Please ask for: Ms Iqraa Malik
Email: iqraa.malik@terraquest.co.uk
Telephone: 0121 234 1390
Our Ref: R/236/21/HH
Your Ref:
Date: 23rd September 2021

Application for Planning Permission for Works or Extension to a Dwelling

Development: Erection of single storey rear extension
Location: 30 Mill Lane Rustington BN16 3JN

2 East facing rear Elevation

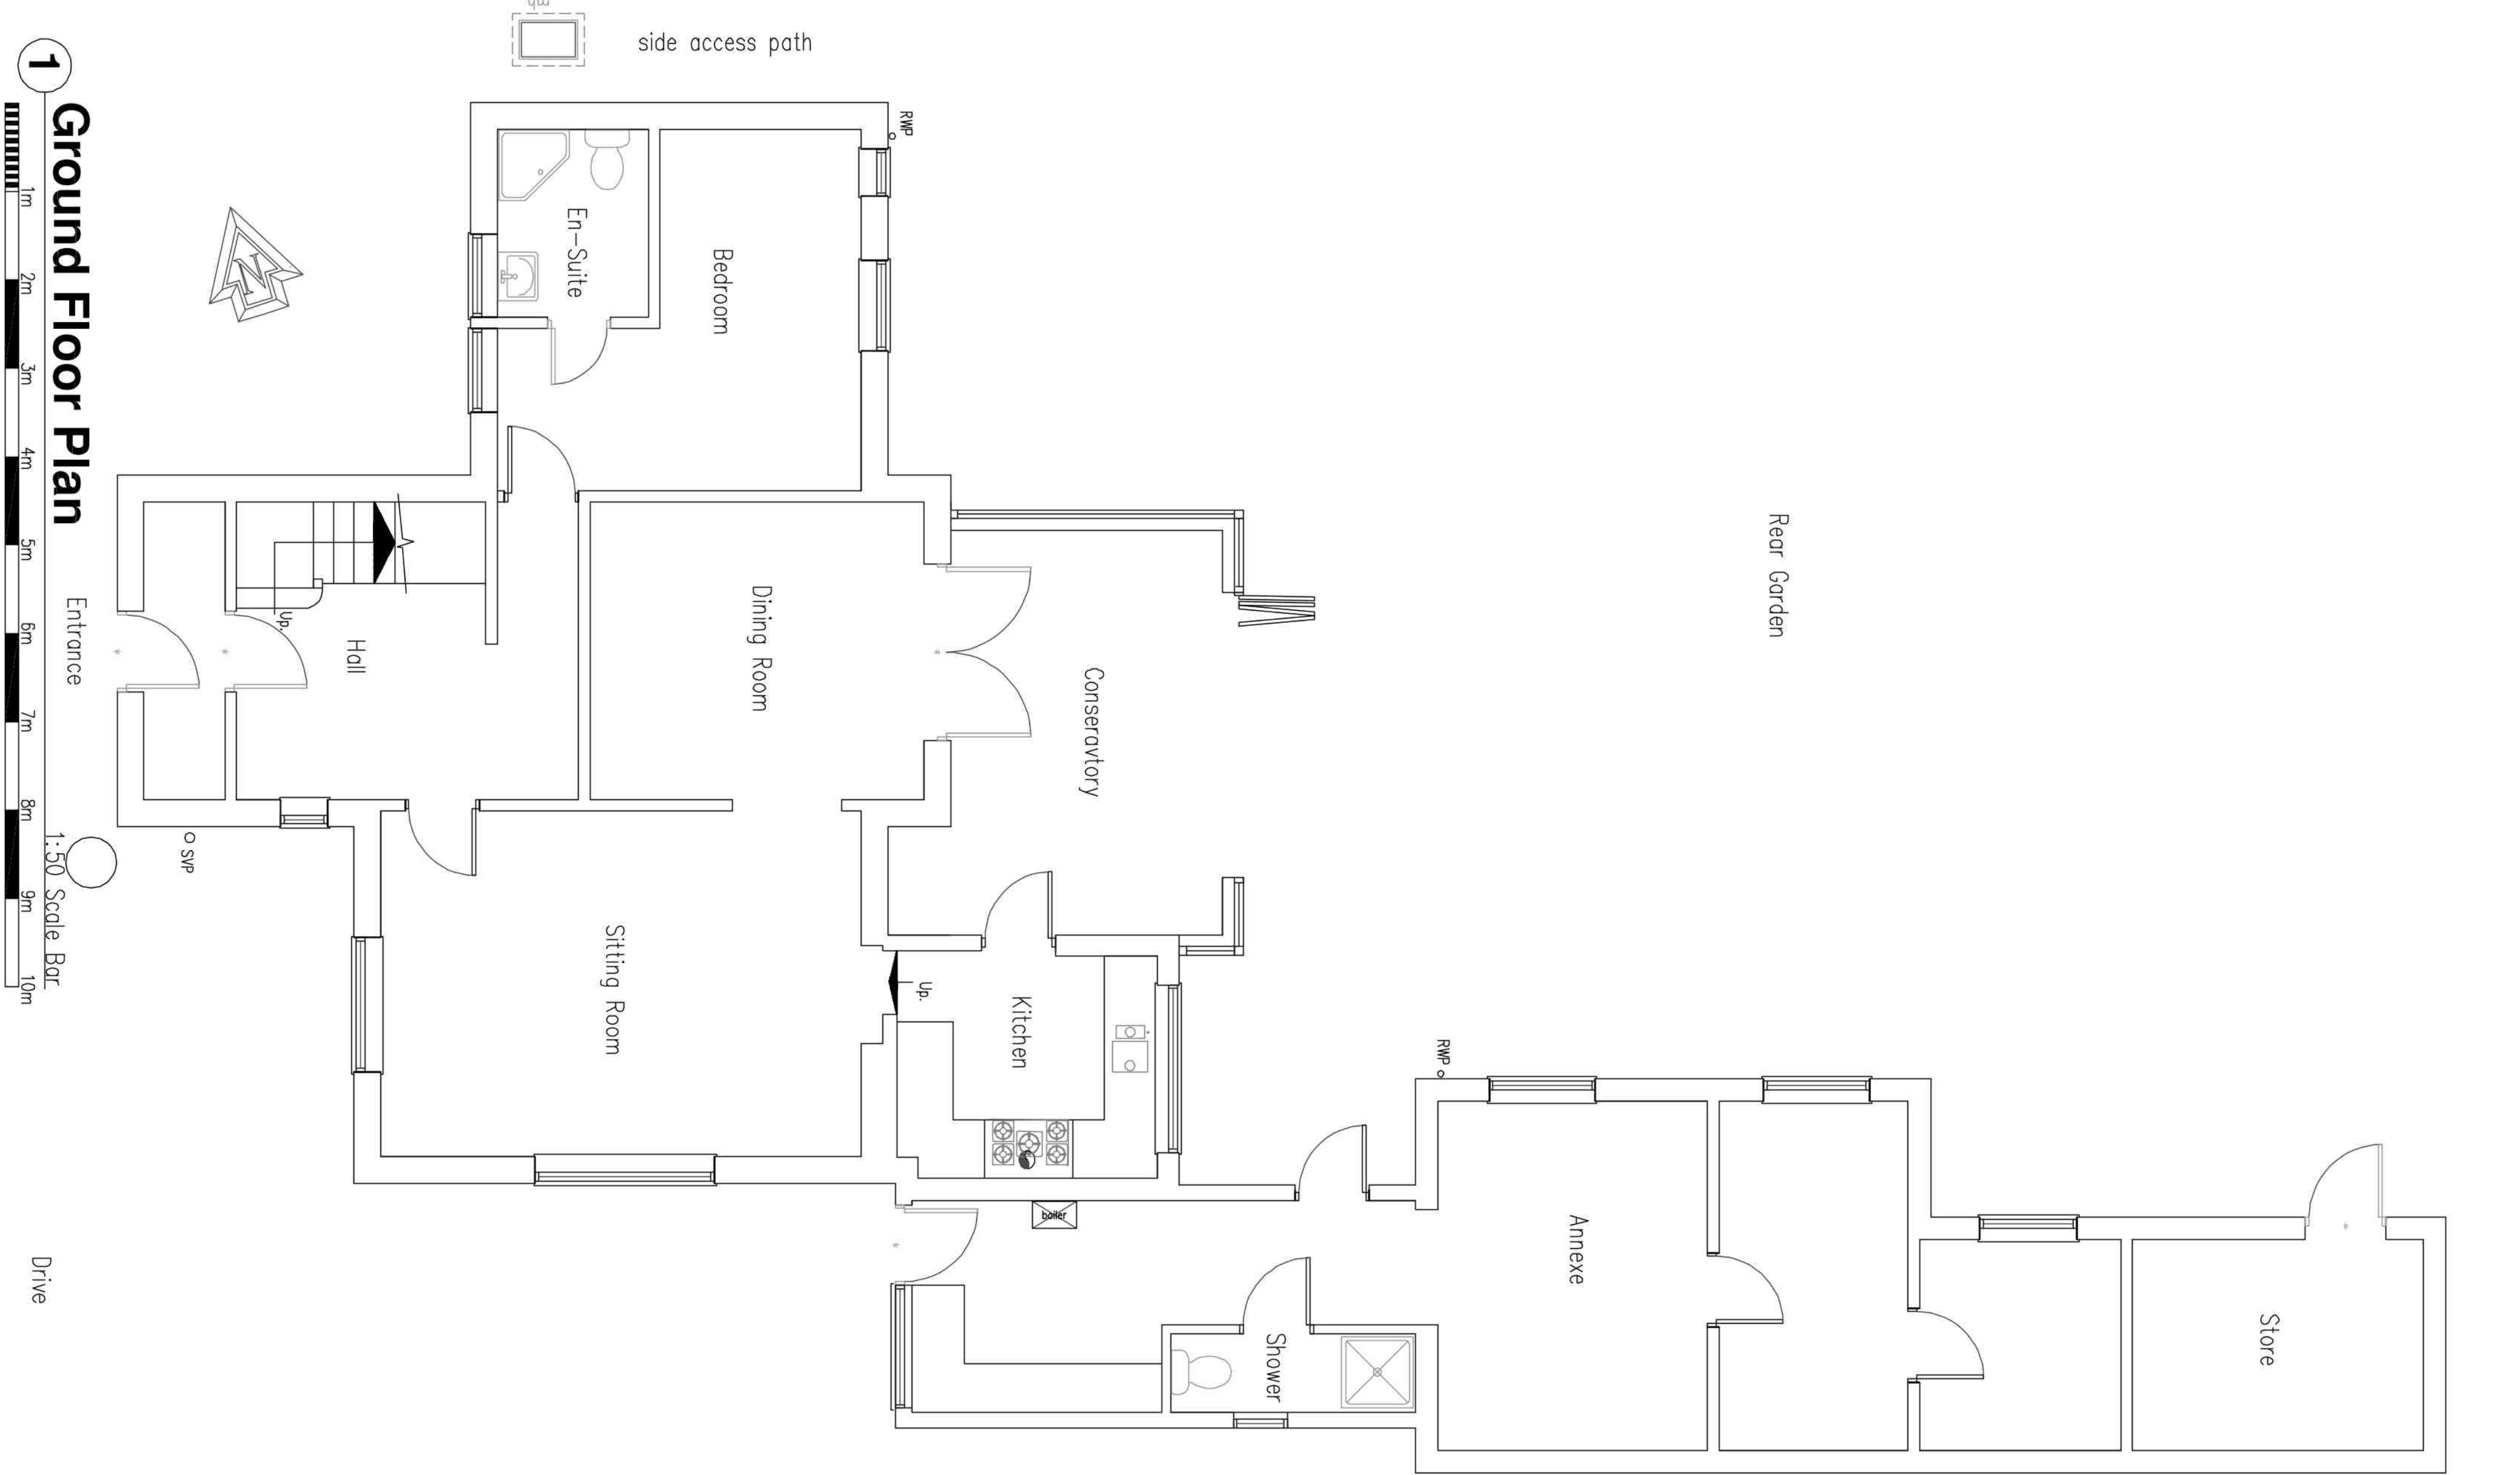
The existing and proposed east facing rear elevations should have a building line to between the store and the room next to the annexe. Please review and amend.

BLOCK & Location PLAN

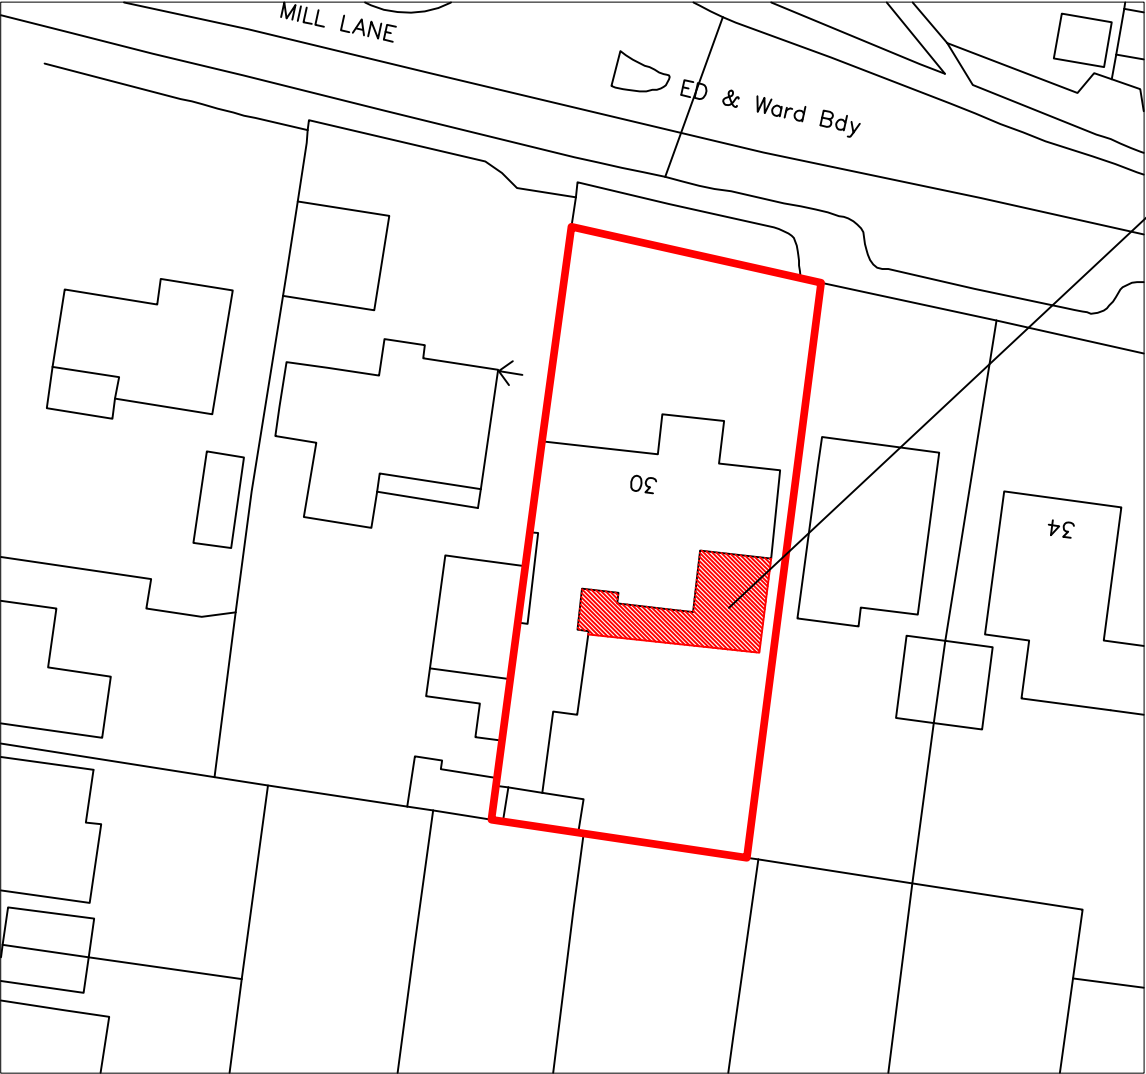
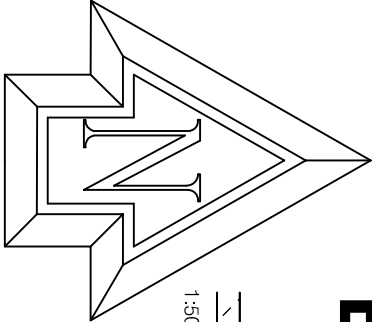
Please submit a location plan at a scale of 1:1250 or 1:2500 for rural areas. Further details of what must be included on the plan can be found in the Validation Requirements List.

Please submit a block plan with dimensions from the proposed extension to the site boundaries at a scale of 1:500. Further details of what must be included on the plan can be found in the Validation Requirements List.
